**Planning Application No: 3/2024/0614**

**Proposal: Retention of and alterations to single-storey extension to side, including alterations to the existing vehicular access and parking provision, and addition of a partial pitched roof.**

**Location: 26 Whalley Road Langho BB6 8EJ**

SITE PLAN

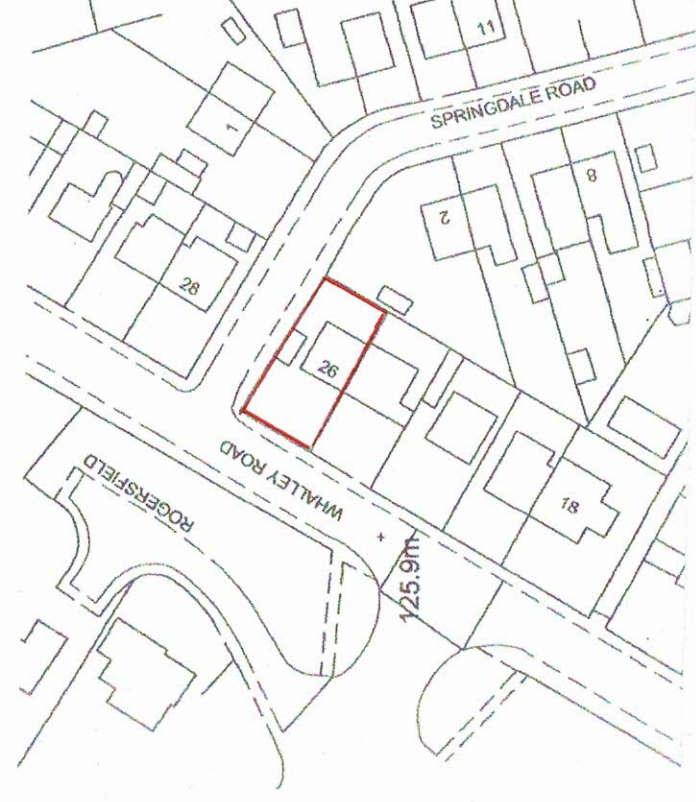
With reference to the Statement submitted Site Description and Proposals. The property is bound by hedgerow to the frontage with timber fencing to the side, and benefits from off-street parking by way of an existing driveway. 'The proposals seek to undertake alterations to the existing drive, enlarging it to allow for improved parking provision and ease of movement to and from the highway' – there does not appear to be a parking plan to show the proposed changes.

The previous drawing for application 3.24.155 Proposed site Plan BE/01/Drawing 04 is attached. Please could a similar drawing be forwarded to show the proposed changes to the existing vehicular access and parking provision.

- The parking areas must be constructed of a bound porous material and created before first occupation up until the lifetime of the dwelling existing in its proposed state. Reason:
